From: Martyn White
Sent: 10 July 2019 14:12
To: Planning.Responses <Planning.Responses@arun.gov.uk>
Subject: WA/44/19/PL

WA/44/19/PL

I note that this application relates to a small-scale extension to the Baptist Church. The church has been identified as a locally listed building, as has the adjoining Landsdwone House. The church is also located within the Walberton Conservation Area

PROPOSED ELEVATIONS

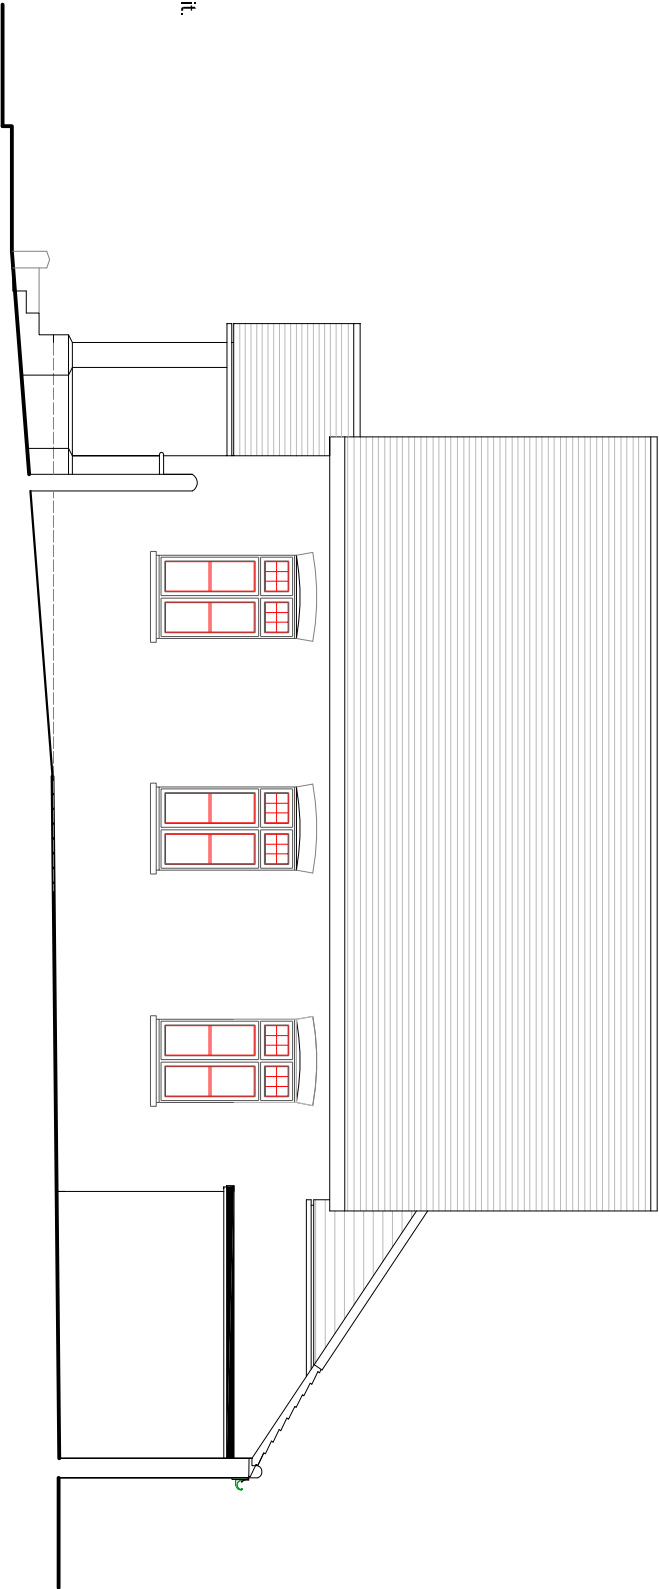
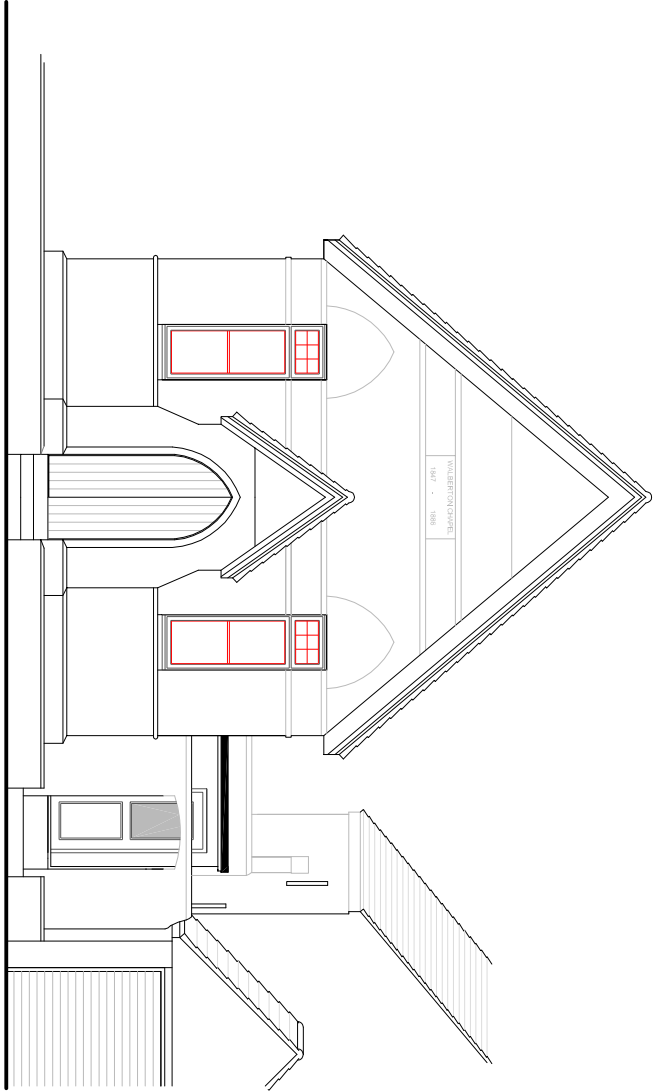
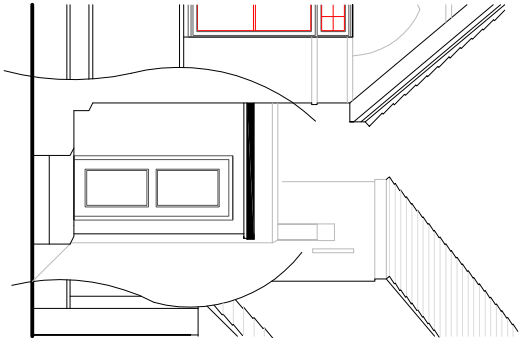
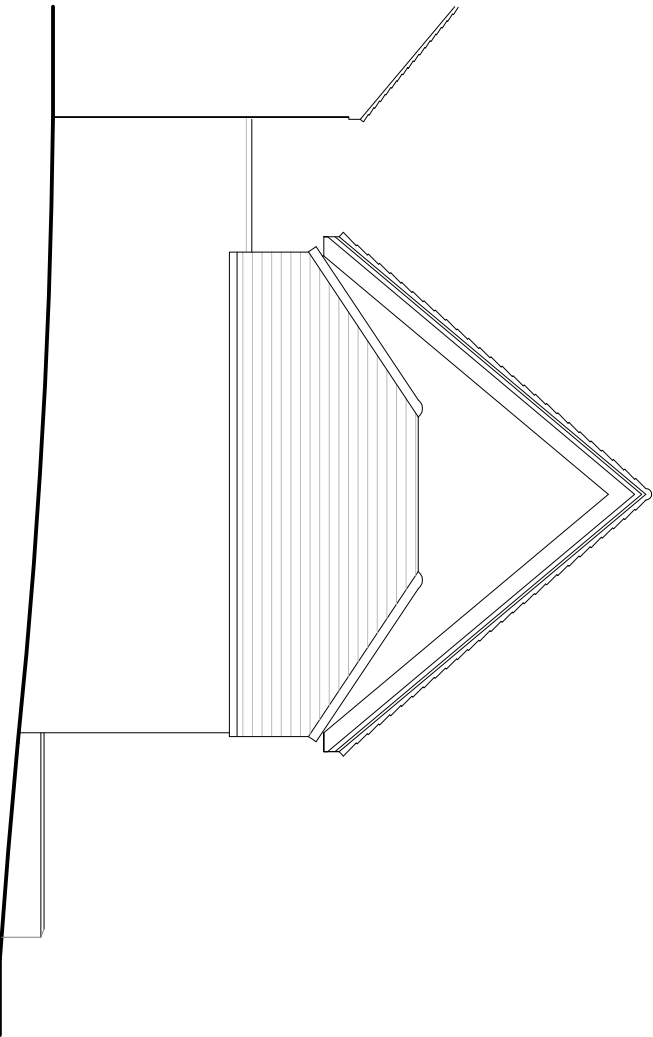
Whilst, the current extension is small in scale, it has been constructed from materials which are not traditional in appearance and appear to contradict with the host dwelling. Such materials are not normally supported. Further, the plans appear to show that the structure is visible from the public realm. Such a concept is considered to be problematic.
